### RE: DJ Cattle & Land Short Plat (SP-08-00020)

Kittitas County Community Development Services Department has determined that the DJ Cattle & Land Short Plat (SP-08-00020) is a complete application and hereby grants **conditional preliminary approval** subject to the following conditions:

DJ CATTLE & LAND SHORT PLAT

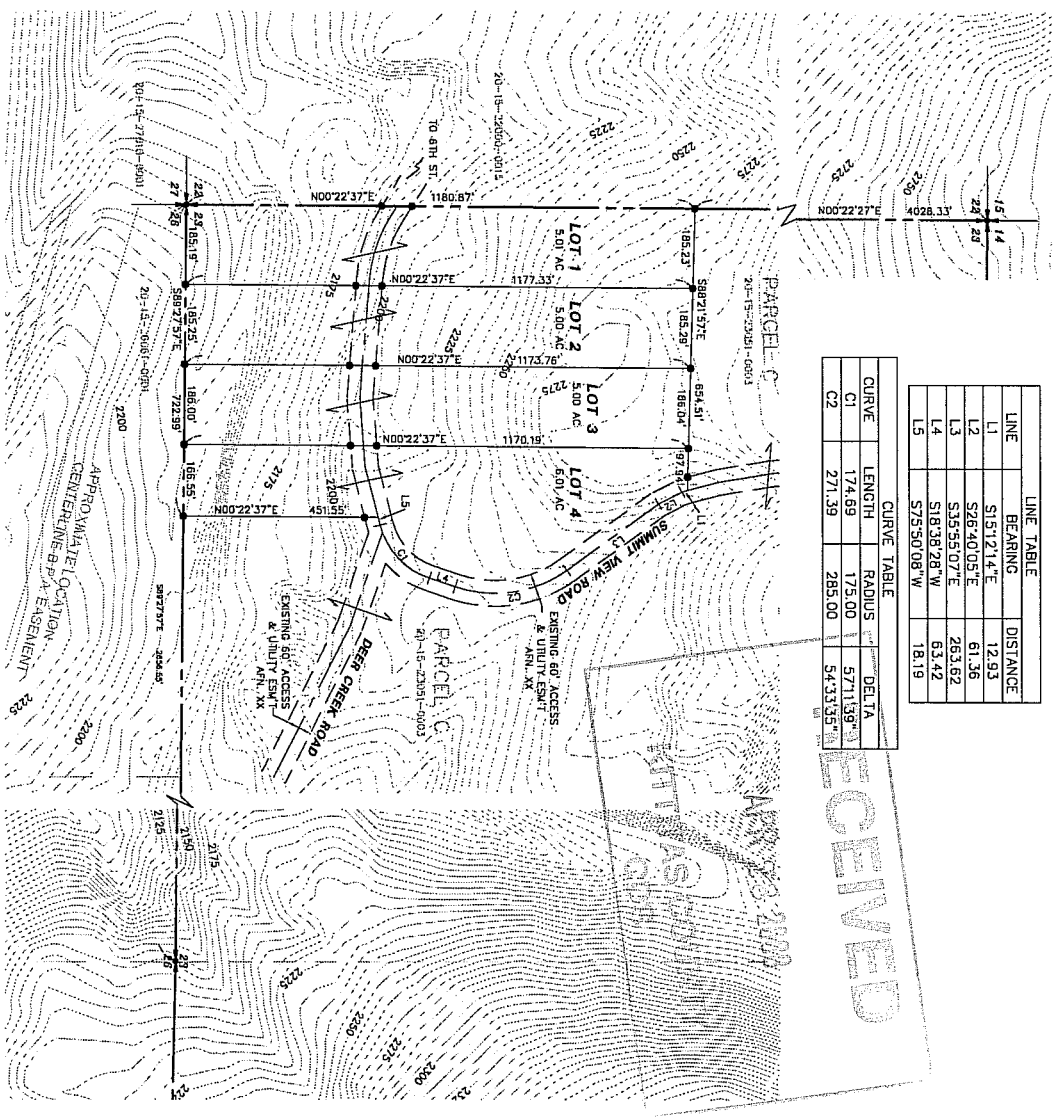
1. Both sheets of the final mylars shall reflect short plat number SP-08-00020 and an accurate legal description shall be shown on the face of the final plat.

2. Current full year's taxes shall be paid for on all tax parcel numbers per requirement of the Kittitas County Treasurer's Office.
3. Plat note number 8 on the preliminary drawings shall be removed.

13. Easement AFN: Easement AFNs for Deer Creek Road and Summit View Road shall be shown on the final plat.
14. Turnaround: An emergency turnaround is required at the end of all roads. The applicant has the option to either: 1) improve and certify Summit View Road from 6<sup>th</sup> Street to a turnaround, or 2) provide a hammerhead or cul-de-sac turnaround within the subject property. A cul-de-sac turn-around shall have an outside right-of-way easement diameter of at least 110 feet. The driving surface shall be at least 96 feet in diameter. A hammerhead may require additional easement. Cul-de-sacs and hammerheads must conform to the requirements specified by the 2006 International Fire Code. Contact the Fire Marshal regarding any additional turnaround requirements.
